Recommendation Report for Planning Permission for Works or Extension to a Dwelling

REF NO: WA/49/26/HH

LOCATION: Foxgloves
Avisford Park Road
Walberton
BN18 0AP

PROPOSAL: First floor rear extension.

Sheet 2 of 4

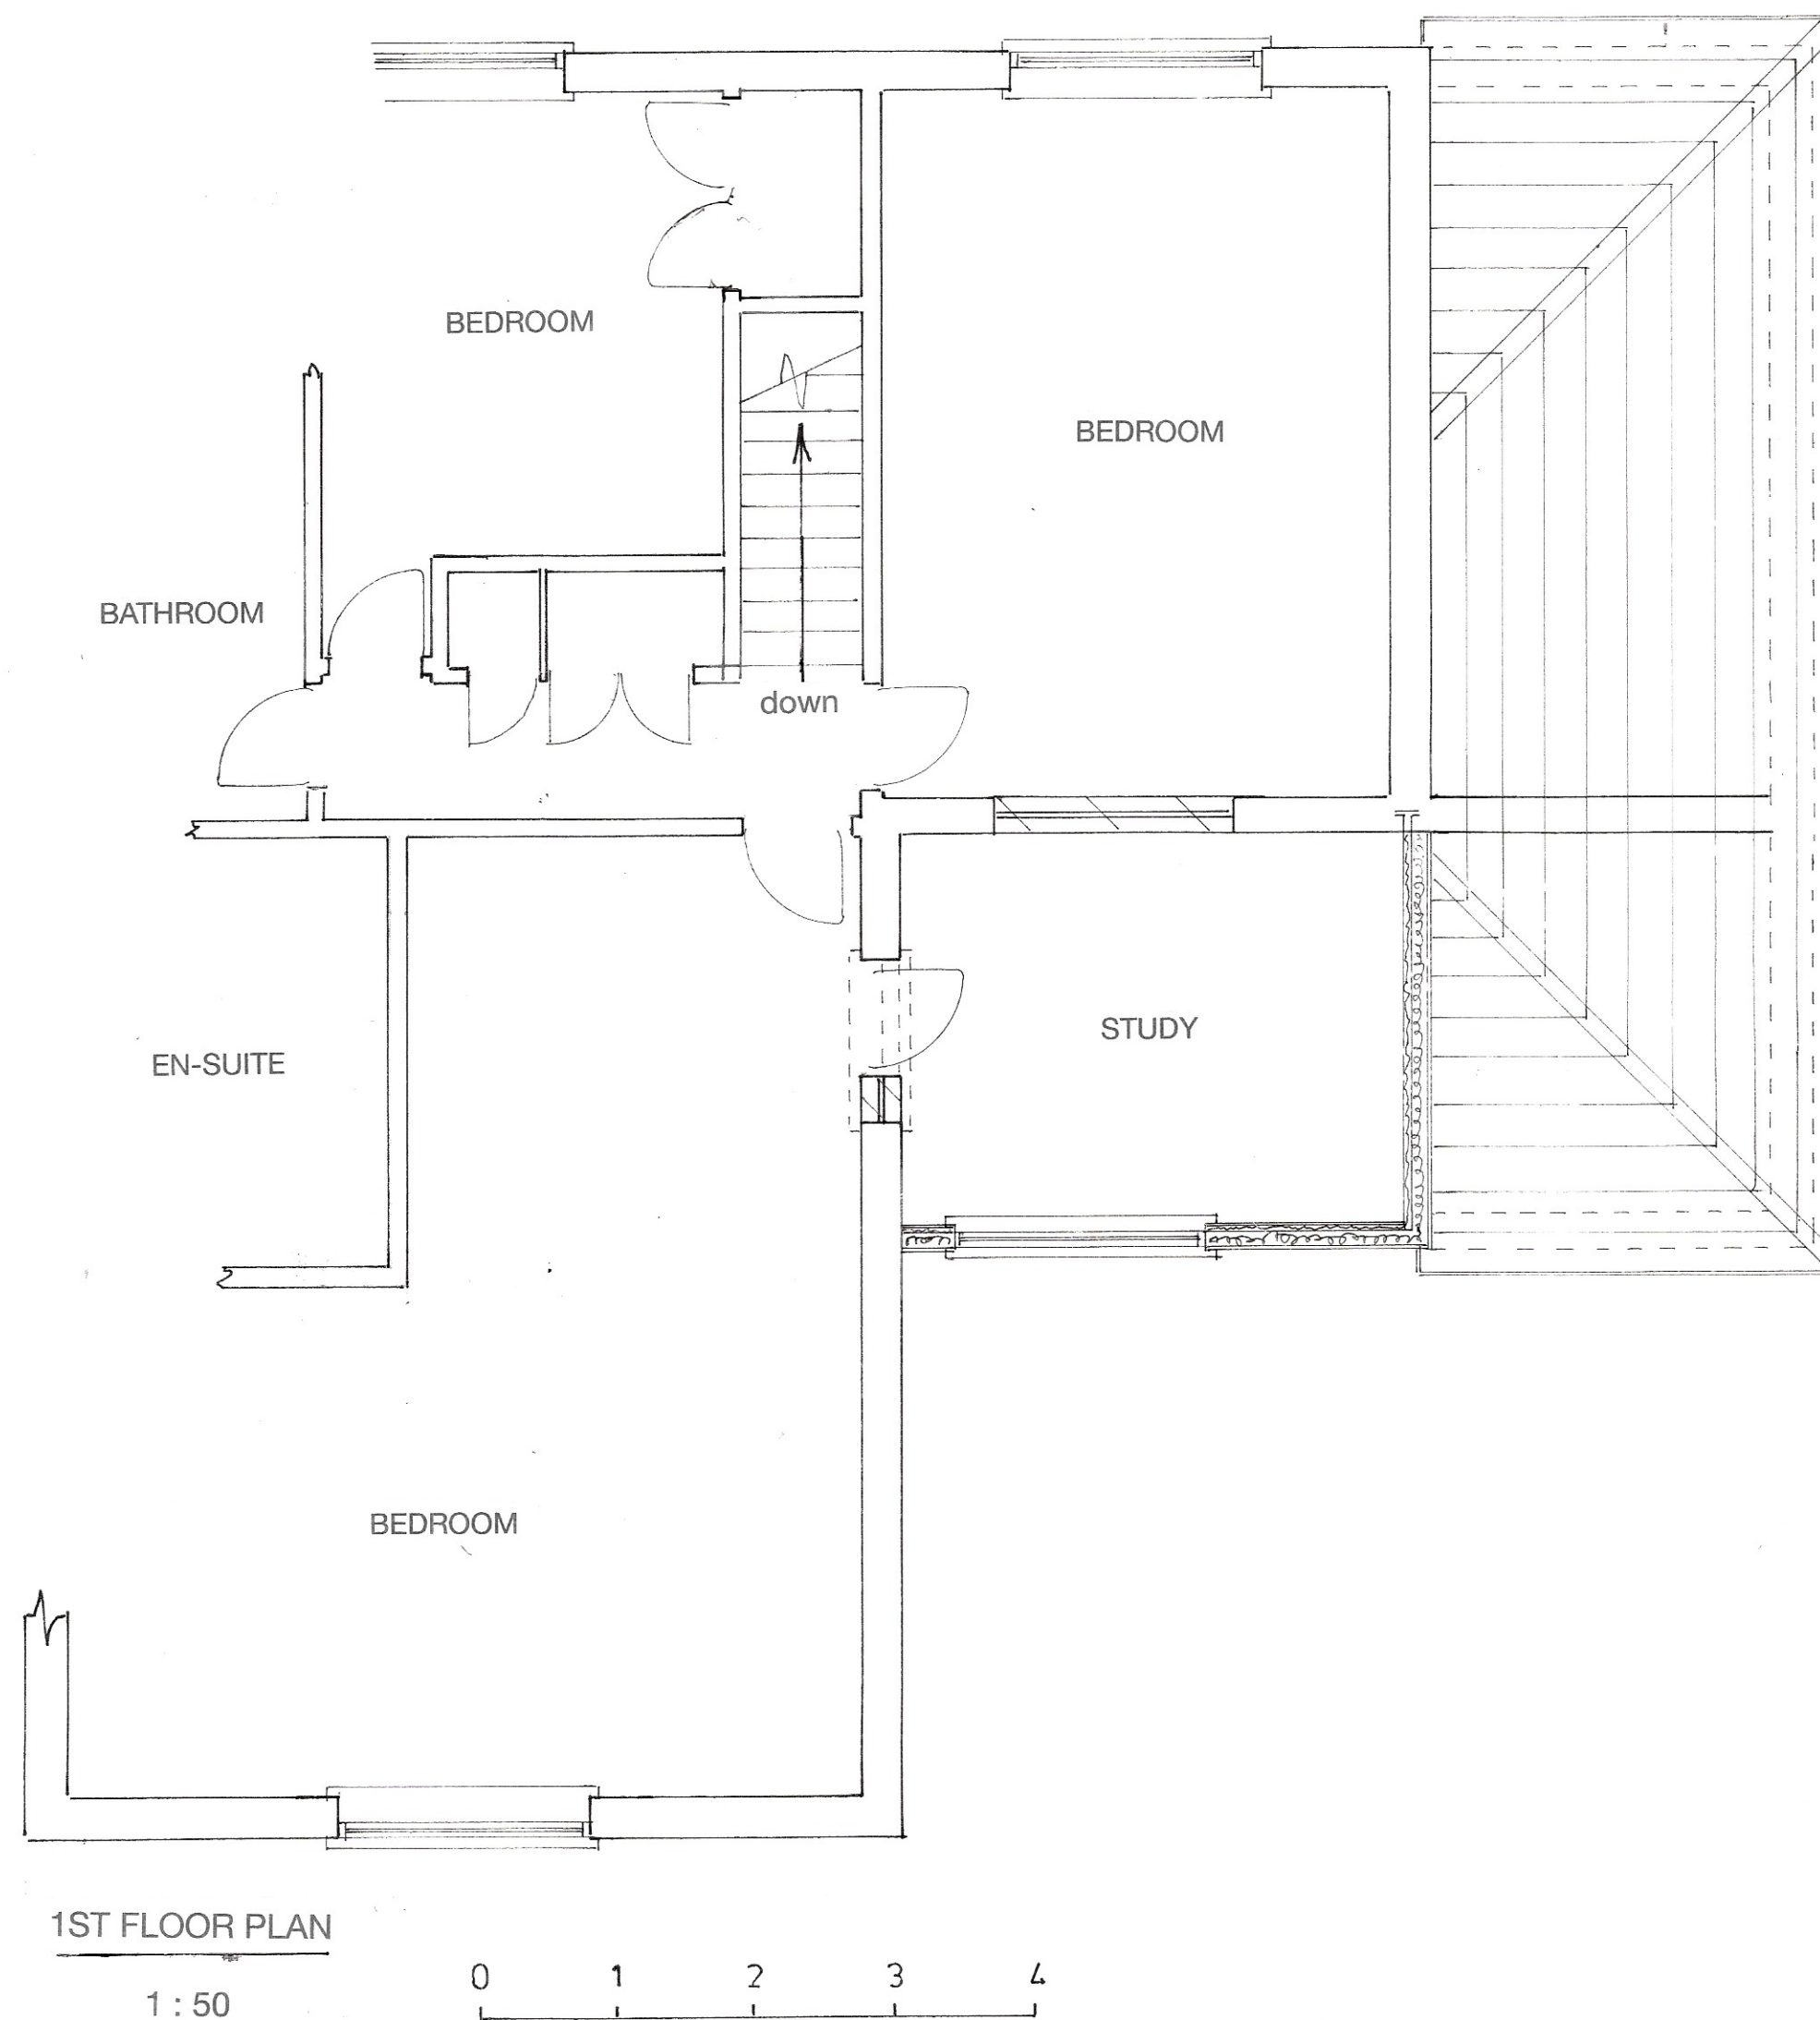
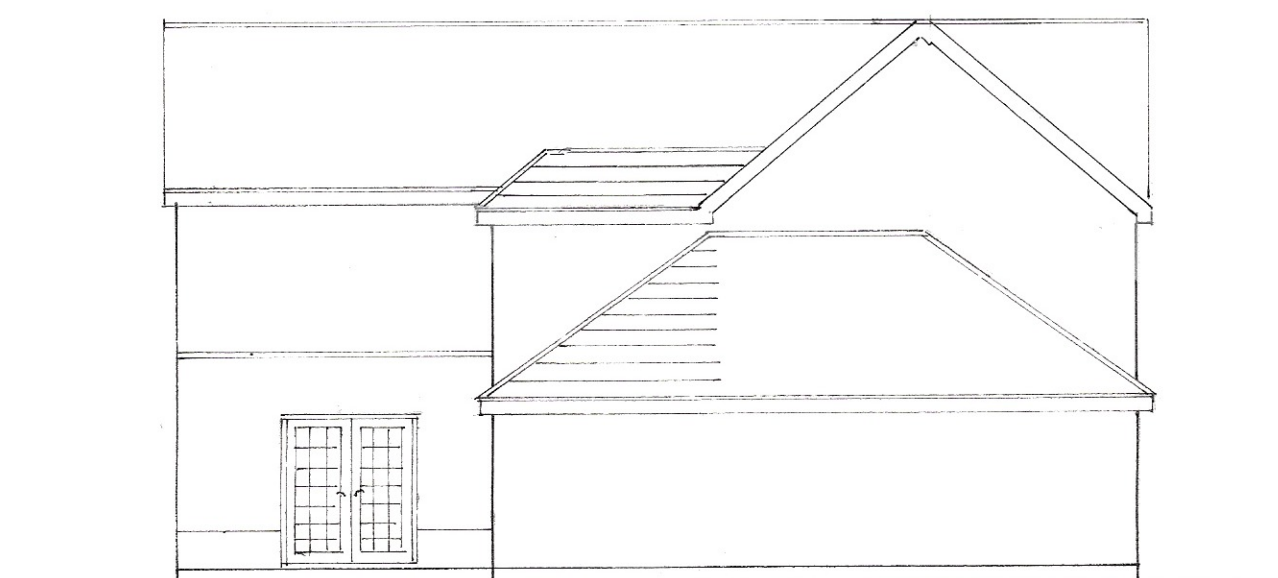
The rear extension would be constructed in the southeast corner of the dwelling, extending 3m from the existing rear wall with a width of 3.8m from the eastern flank. The extension would be built above an existing flat roof, and would itself have a crown roof, more appropriate considering the character of both the host dwelling and locality. Further to this, a pitched roof would be added to the remainder of the ground floor flat roof, adjoining the existing ground floor pitched roof, resulting in a congruous, logical form that responds well to the host dwelling.

Set within the existing footprint of the host dwelling and set down 1.8m down from the roof ridge, the extension would be subservient addition. The Arun Design Guide (ADG) states that first floor extensions should maintain a distance of 21m to any dwellings at the rear; the extension would maintain a policy compliant distance of 44m to the rear boundary.

The extension would be finished with white, cedar cement board cladding. Cladding (both mock-wood and light green) can be seen at Two Ways and Rivendell, the first two dwellings on the northern side of the road. Given that the proposed cladding would be white, sited to the rear and there are other examples of more vibrant cladding, there would be no resultant harm to design or visual amenity. The roof of the extension would be finished with tiles to match the host dwelling.

Set within the existing footprint of the dwelling, set in 4.2m from the eastern side boundary, there would be no overbearing impacts to the neighbouring amenity.

Existing built form would screen the extension from the west, resulting in no harm by way of overshadowing to the western neighbour. It is noted that there would be a breach of the 45-degree rule when taken from the first floor window at the neighbouring property to the east (Mayfield). However, the breach would be minimal, caused only by the addition of the pitched roof over the existing ground floor footprint, not by the extension itself. As such, there would be no undue harm to by way of overshadowing to the eastern neighbour.

The first-floor extension would have a singular window on the south elevation, providing similar, oblique views of neighbouring gardens as the existing first floor rear fenestration. Given the modest difference in views, and existing boundary treatment, there would be no undue harm by of overlooking.
